Application for a Non-Material Amendment Following a Grant of Planning Permission

Attic conversion/extension to the later rear lean-to addition.

23/02234/FUL

FIRST/ATTIC FLOOR PLAN

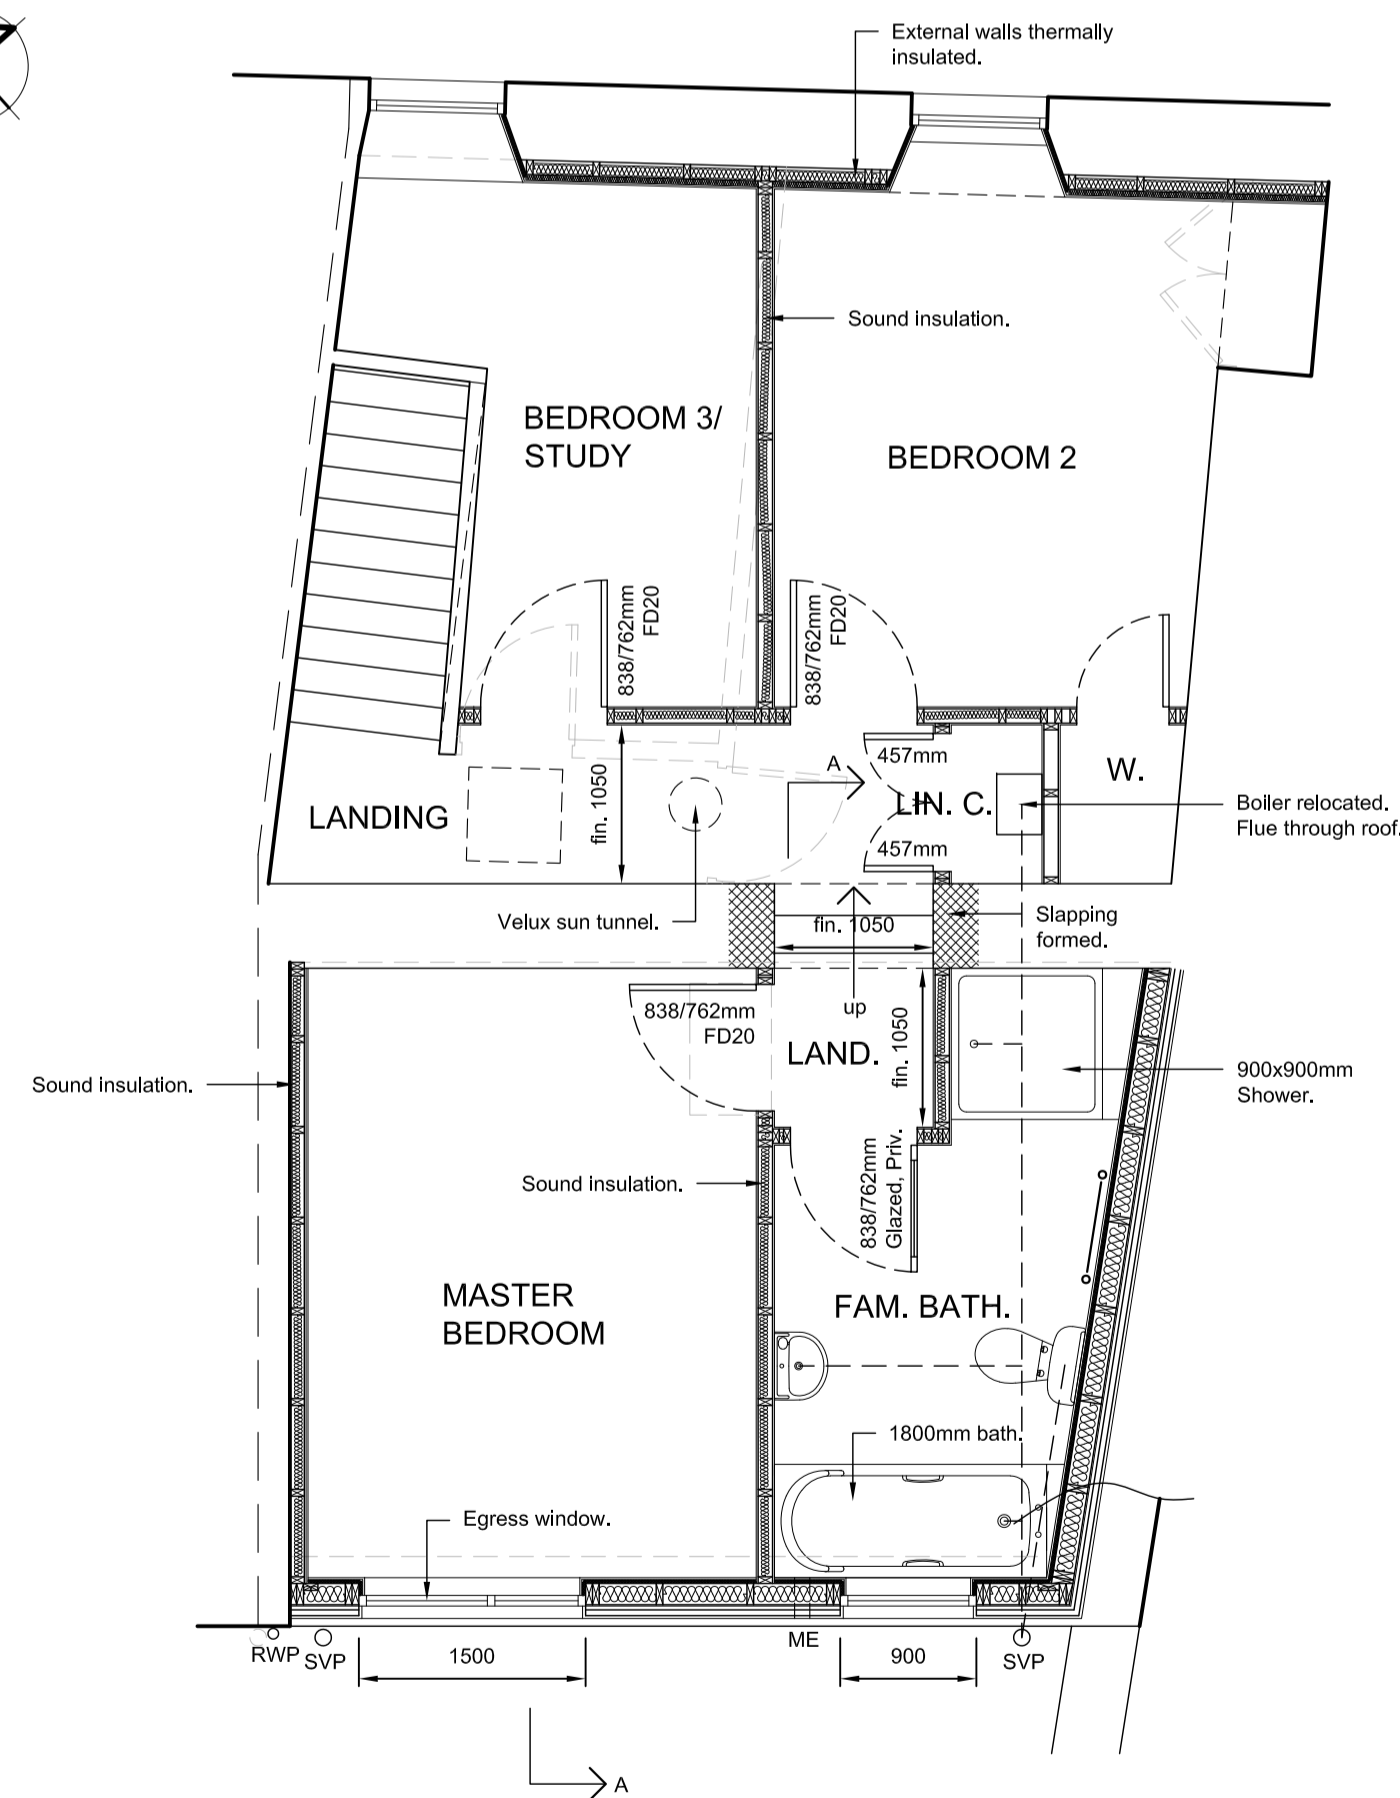
Swapping around of the first floor Master Bedroom and Family Bathroom including swapping around of the windows serving these rooms.

In order to take into consideration some of the neighbours comments at no. 50 Middle Street, so that the Master Bedroom is not looking out over the neighbours garden and positioned so it looks more out over the applicants garden.

Planning Drawing (As Proposed) 1769/23/05B
